Application No: BN/10/21/HH
Site Address: 2 Park Cottages Goodacres Barnham PO22 0JE
Description of works: Loft conversion consisting of hip-to-gable roof extension and rear box dormer with roof windows to front elevation.

Thank you for your internet representation made on 11th March 2021 which has been recorded as an objection with the comments as follows:

Drawing
Proposed Elevations

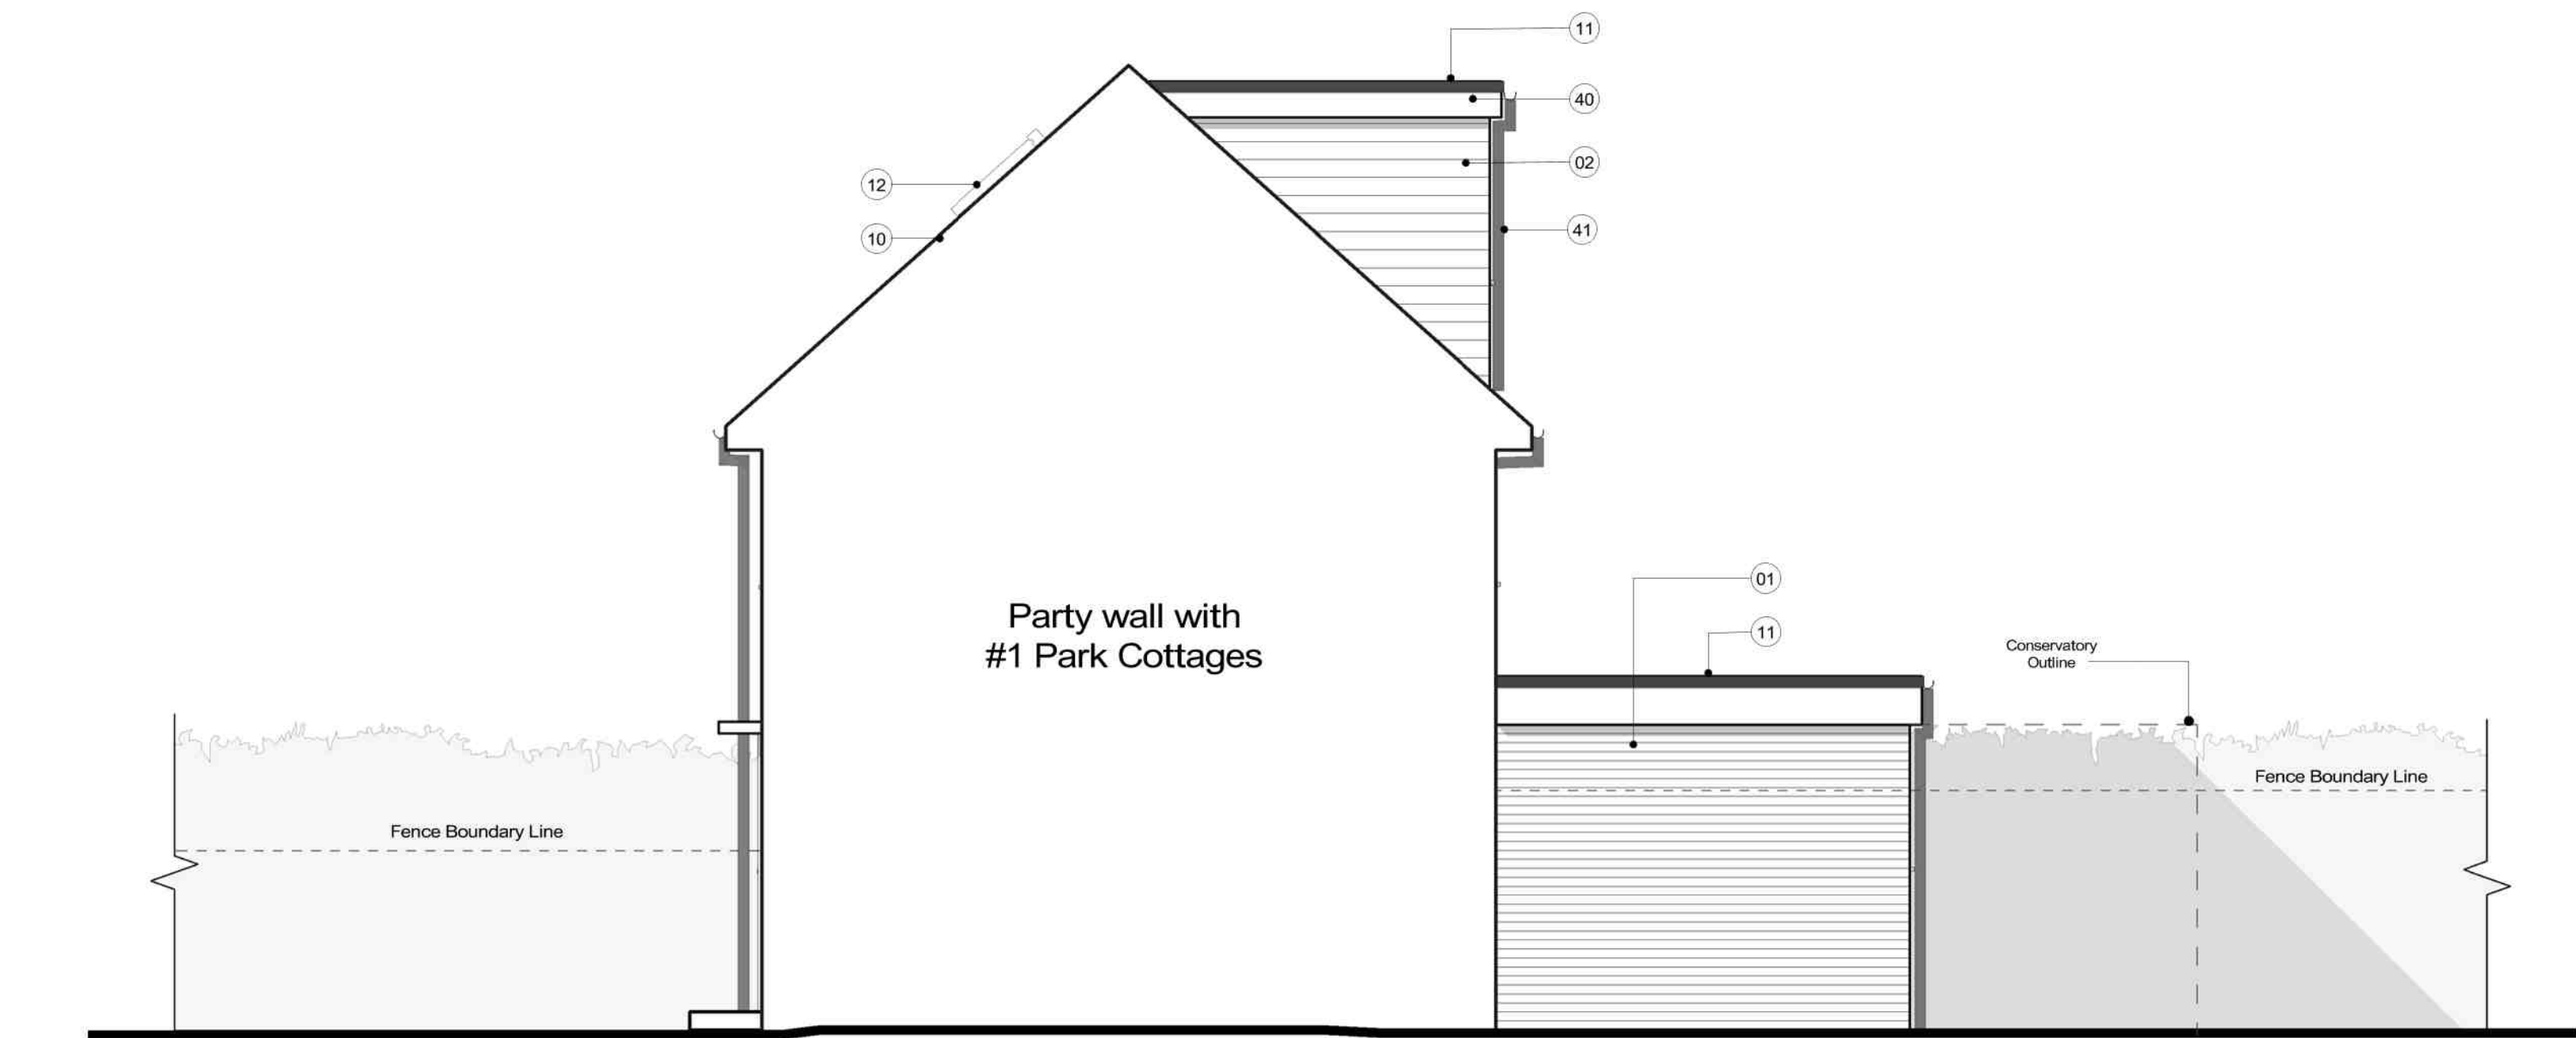
- the extension is too large and not in keeping with area
- the proposed extension will mean that neighbouring gardens will be directly and entirely overlooked and privacy to these neighbours will be lost.
- Park cottages have been built as a pair. 1 and 2 park cottages were built symmetrically in 1950's, to have an extremely large extension out the side and rear of one of the cottages will ruin the aesthetic of the two cottages and effect the history of not only this property, but also the matching cottage. The extension on one cottage will spoil the character of both cottages.

- the extension will be visible from all three sides. The back, side and front and this is not in keeping with the area.
- the effect of intensive and intrusive building works will be far too detrimental to the health and mental well-being of elderly neighbours on each side of the property and to the residents of Churchill House, warden assisted flats, who all have a right to enjoy quiet use of their homes. The effect of construction noise is especially concerning given that residents are in lockdown and unable to leave homes due to covid.
